KIRKLEES METROPOLITAN COUNCIL INVESTMENT & REGENERATION SERVICE

DELEGATED DECISION TO DETERMINE APPLICATIONS FOR CONSENT, AGREEMENT OR APPROVAL REQUIRED BY CONDITION

Reference No:	2025/44/91094/E
Site Address:	127, Marsh Lane, Shepley, Huddersfield, HD8 8AS
Description:	Discharge of details reserved by conditions 5 (foul, surface water and land drainage scheme), 6 (assessment of the effects of storm events), 7 (surface water drainage scheme), 9 (details of the junction and associated highway works), 11 (proposed internal adoptable estate roads scheme), 12 (construction traffic schedule) and 13 (survey of the highway on Marsh Lane) of previous permission 2024/91202 for erection of eight dwellings with associated access and external works
Recommending Officer:	Nina Sayers

DECISION – Discharge of Conditions – Split Decision

Typical Tanked Geo Cellular Crate Detail

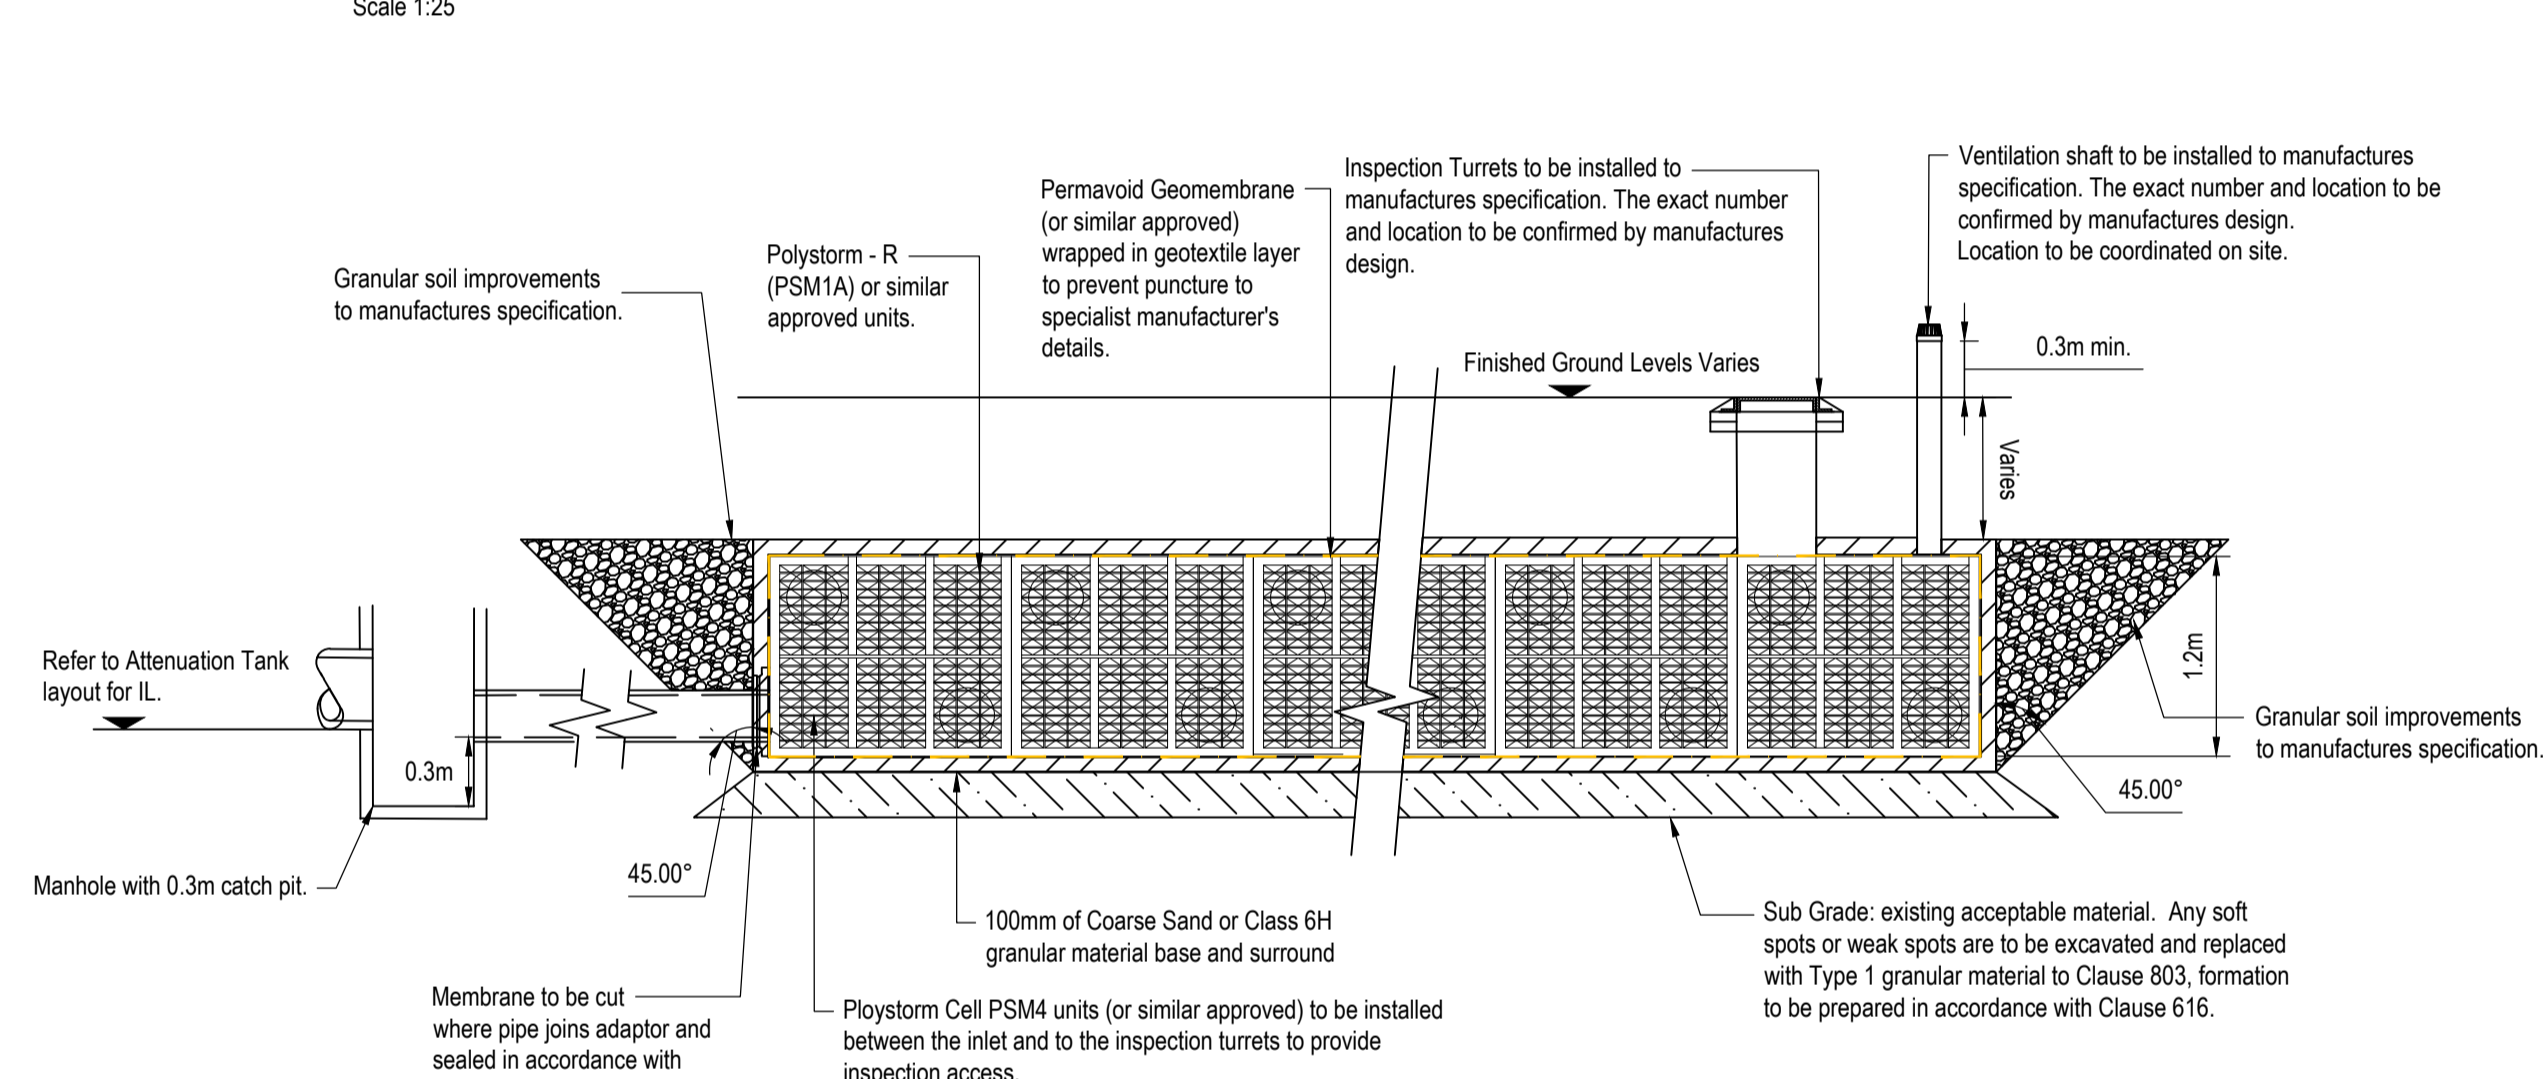
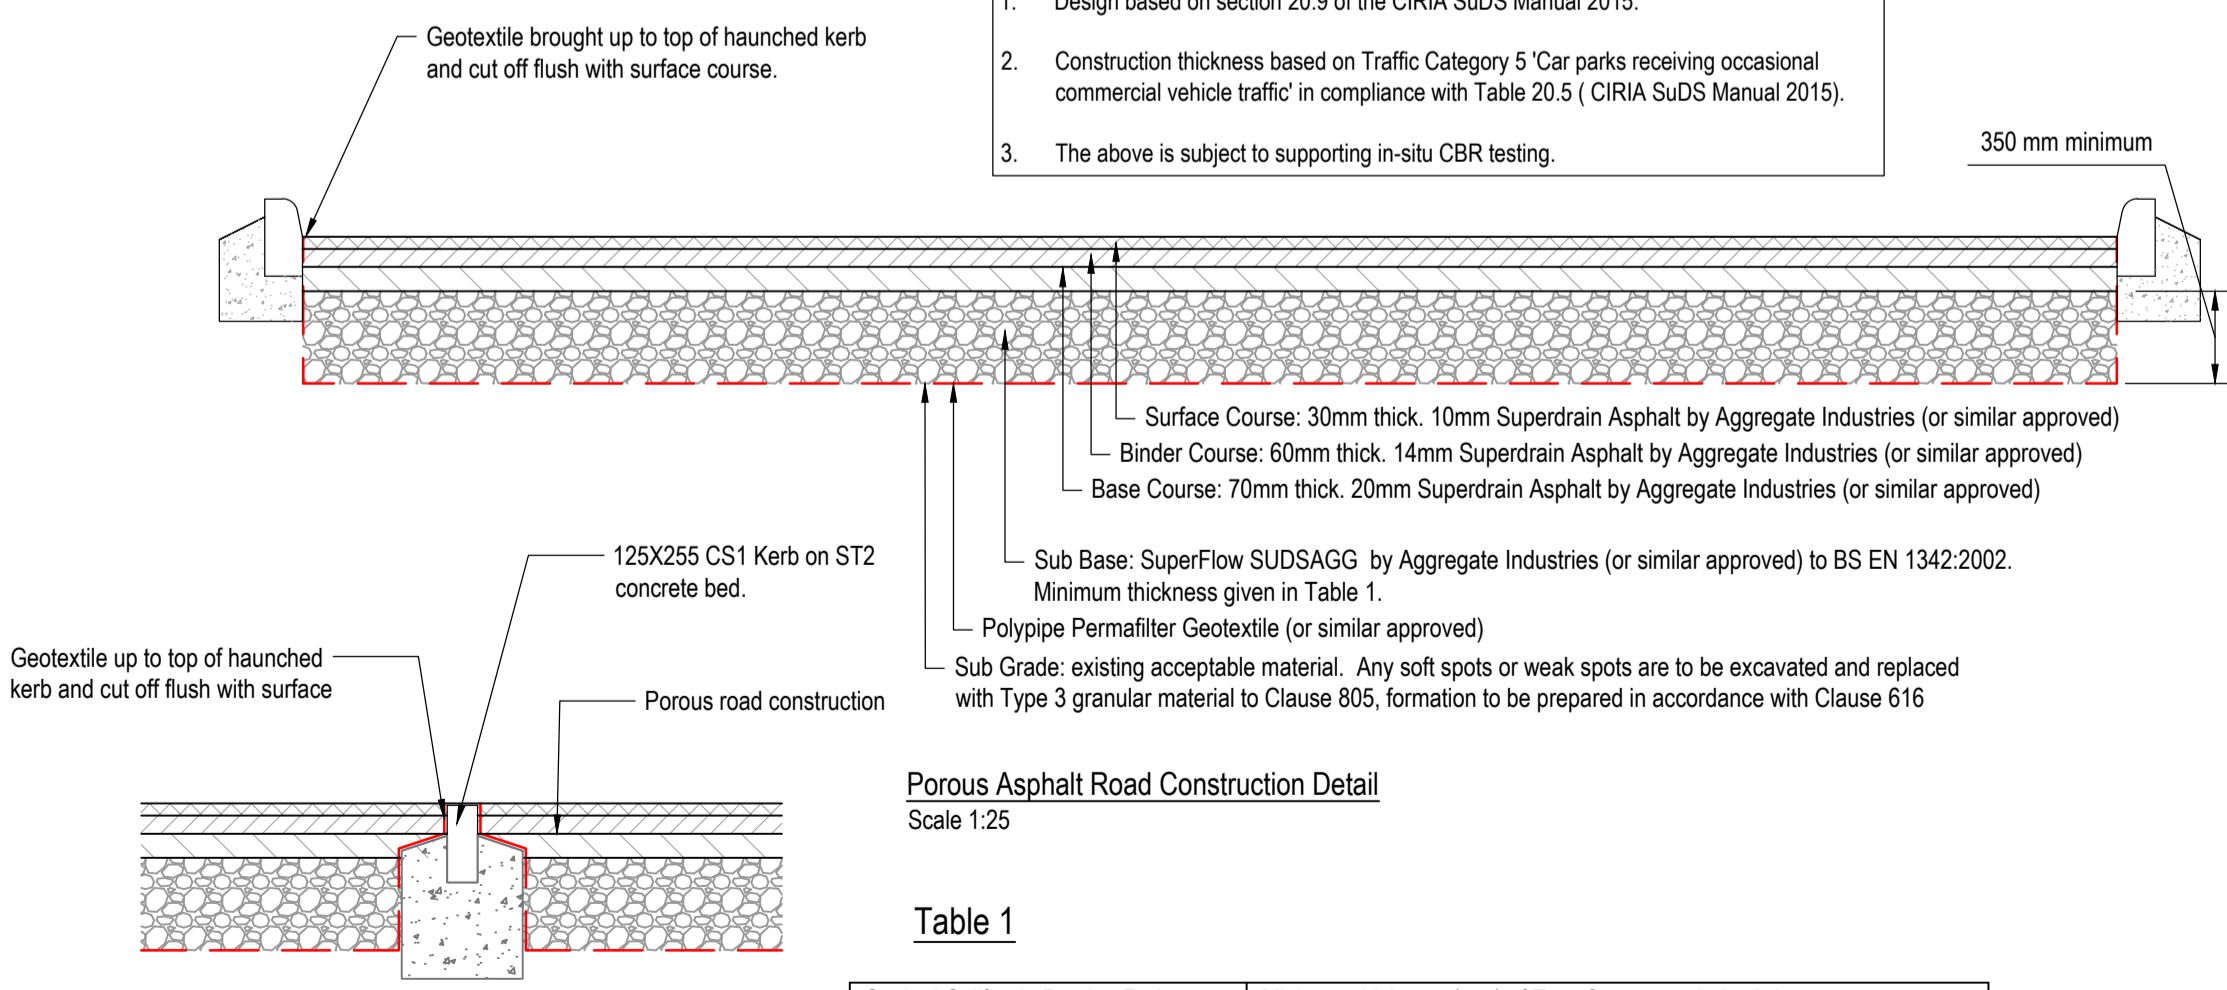
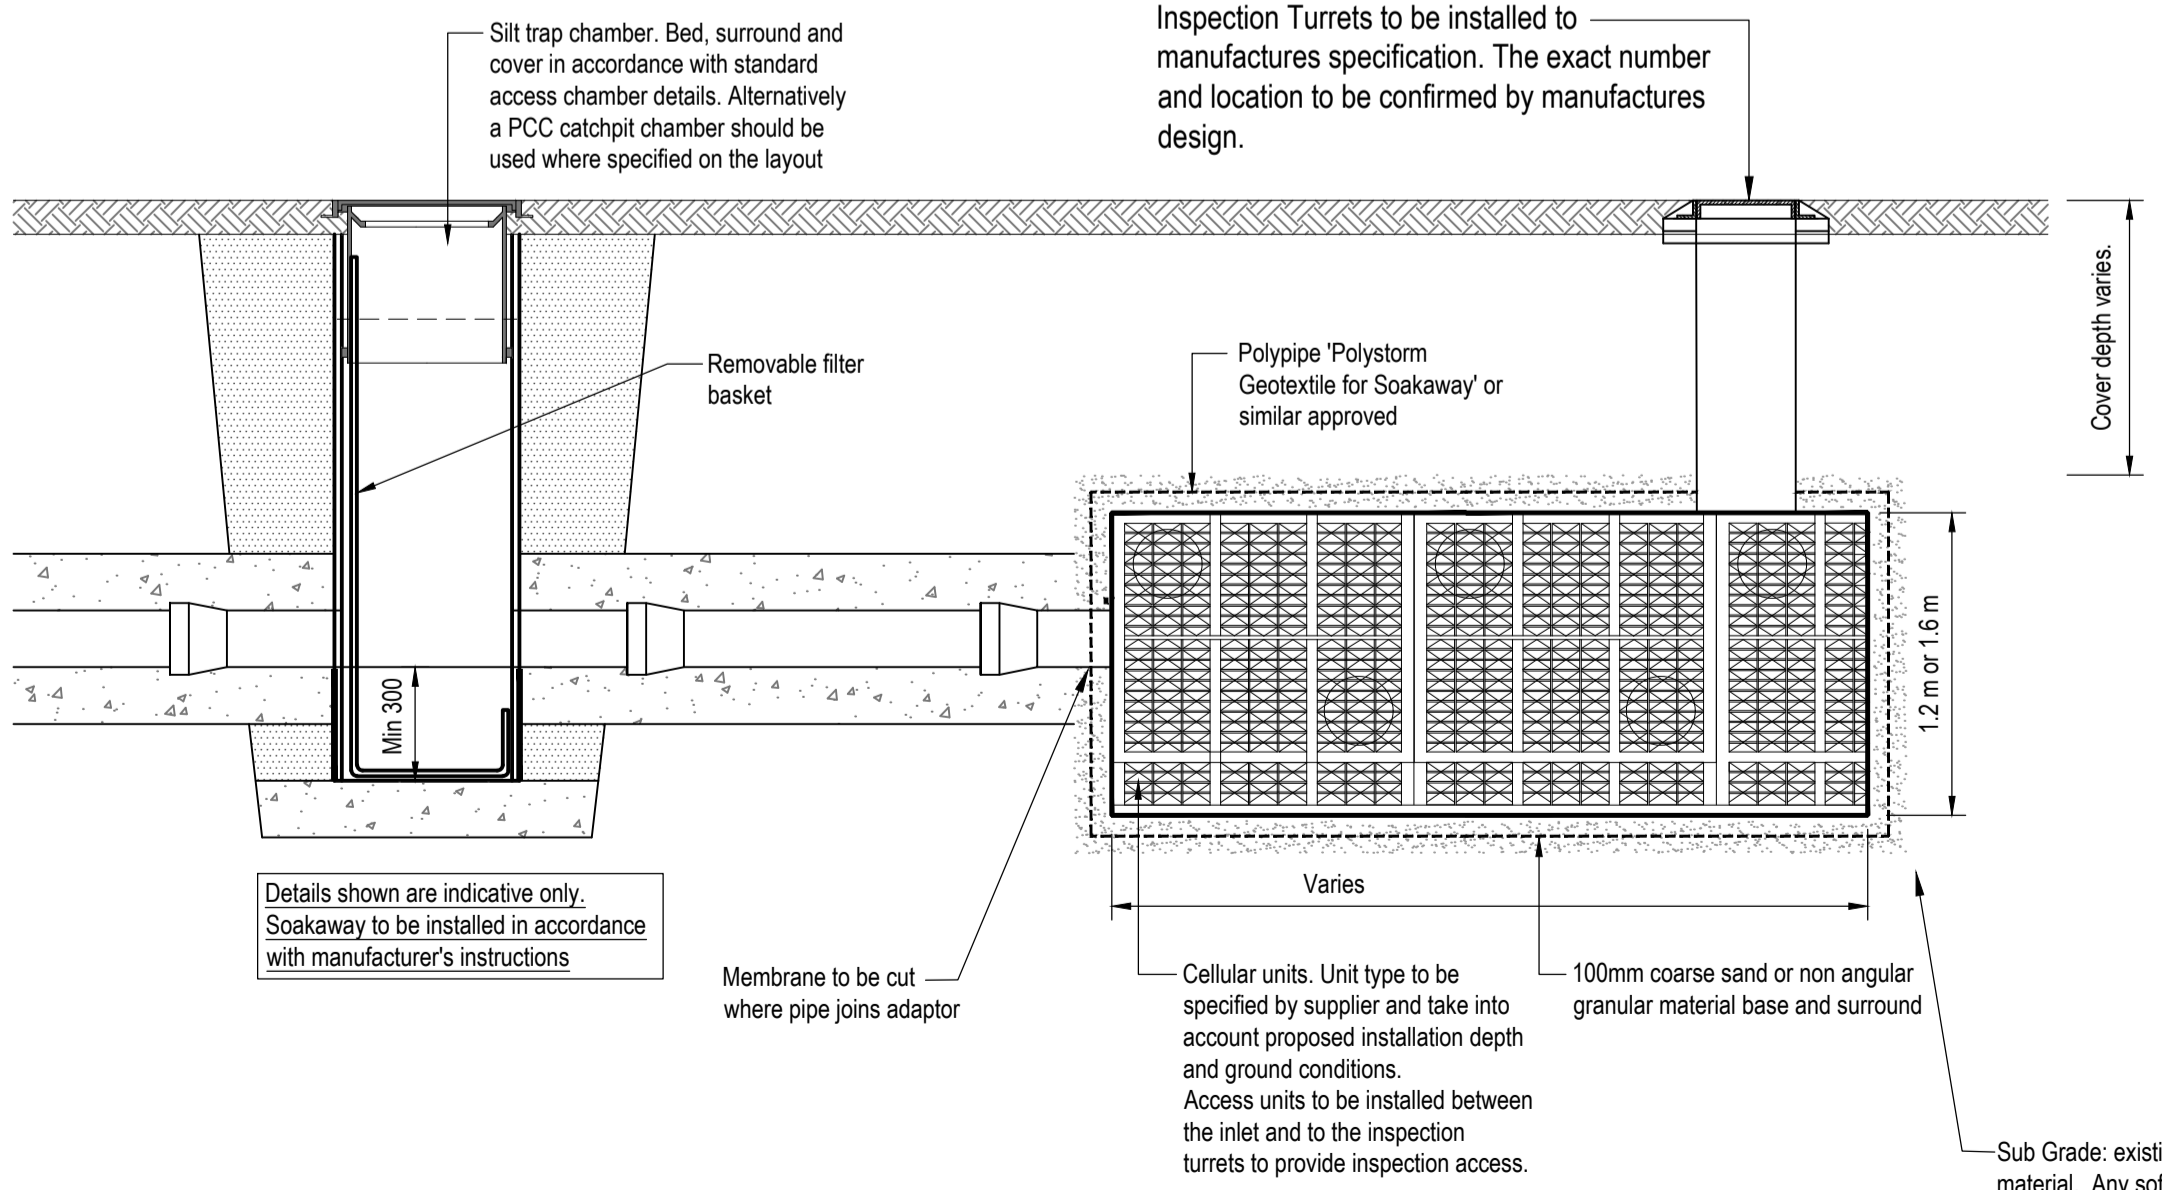
- Evidence the surface water outfall across third party land has been agreed in writing with the landowner;
- Individual soakaway tests;
- Explanation for why the hydrobrake chamber cannot be made deeper
- Access for inspection and maintenance of the geocell tank; and
- Revisions to the hydrobrake design.

Revised plans and additional information were received as listed above. The LLFA confirms acceptance of the soakaway test results and associated Causeway calculations contained in the Technical Note and the 3rd party landowner letter. They therefore recommend that condition 5 can be discharged in this instance.
